**Nationally Significant Infrastructure Project: EN010149
Springwell Solar Farm**

**Response to The Examining Authority's written questions and requests for
information (ExQ1) issued on 13th May 2025**

Prepared by Lincolnshire County Council (LCC)

June 2025

Abnormal Indivisible Load Route
Sheet 1 of 1

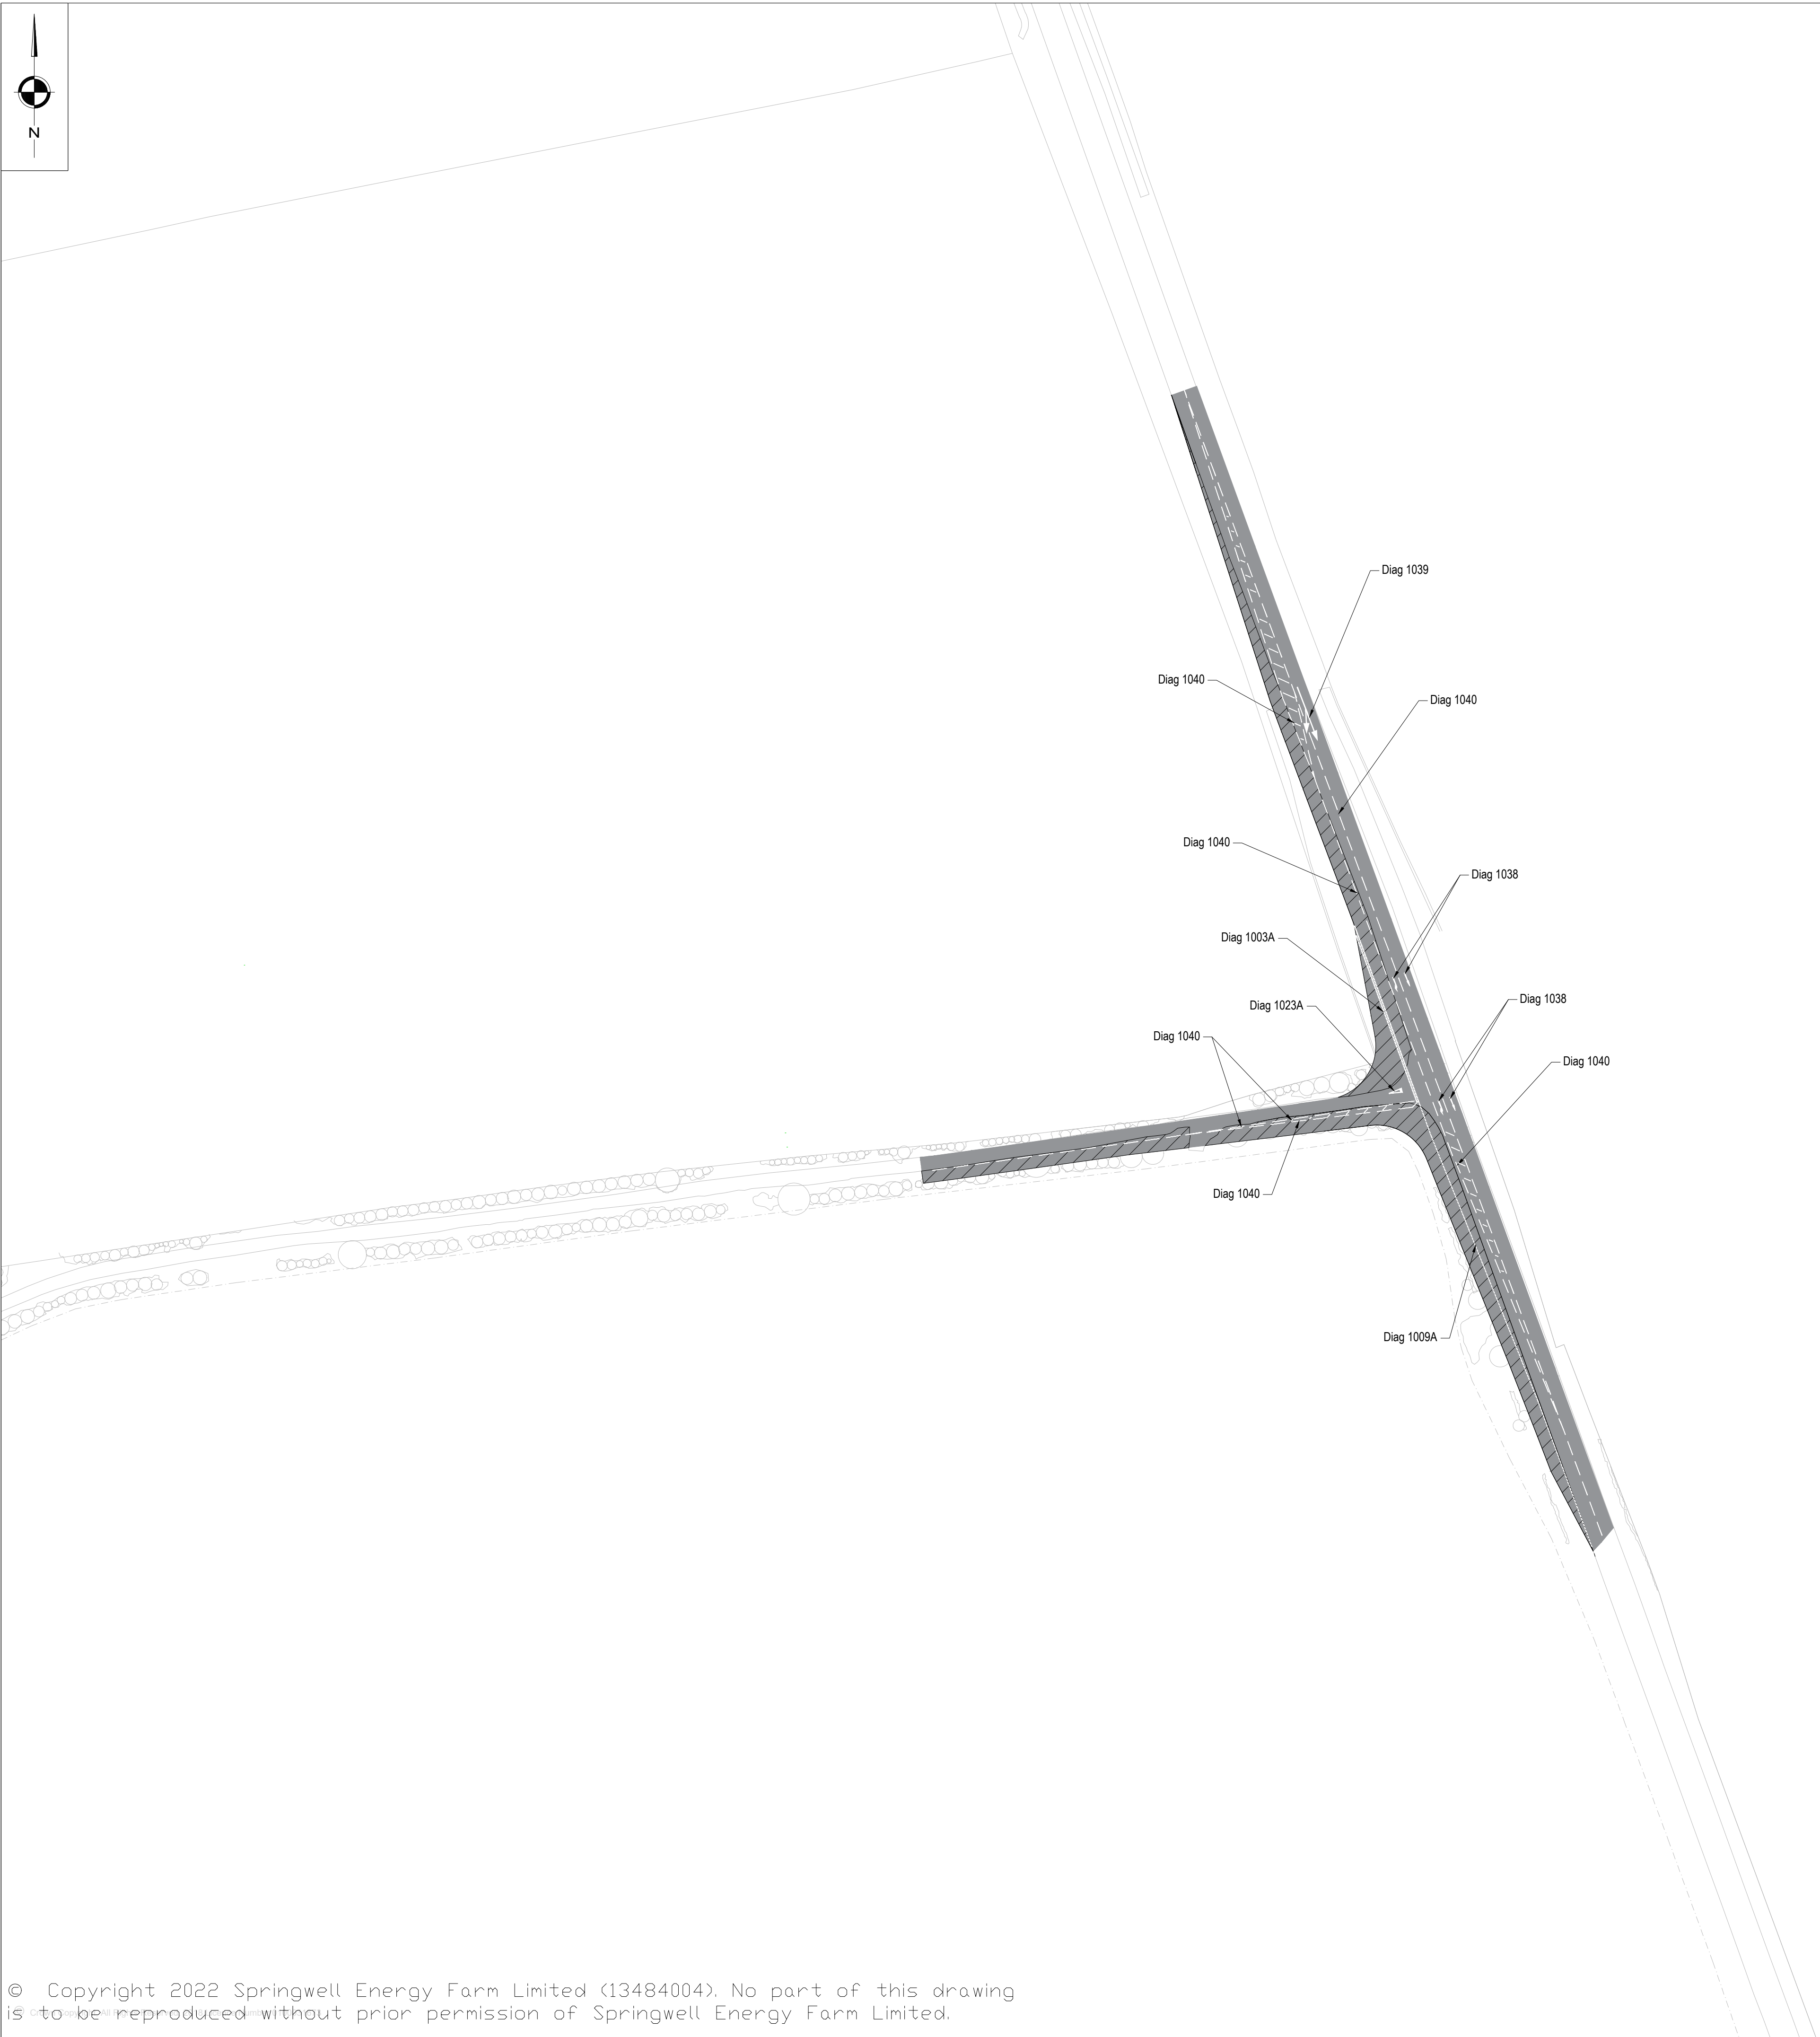
ExQ1	Question	LCC Response
	b. LCC , do you agree with the Applicant's view?	
1.13.5	<p>Abnormal Indivisible Loads Route</p> <p>The oCTMP [APP-0141, Appendix 3] sets out the route that Abnormal Indivisible Loads (AILs) would follow to the application site. NR [RR-296] wishes to ensure that AIL movements under or near the Bridges are undertaken safely at all times and has set out that its engineers will be considering the details in the oCTMP.</p> <ul style="list-style-type: none"> a. NH and LCC, is the proposed route considered to be acceptable? b. NR, provide an update on your consideration of the oCTMP. c. Applicant, set out how any AIL movements will safeguard any bridges along the route 	Yes, the AIL route is acceptable.
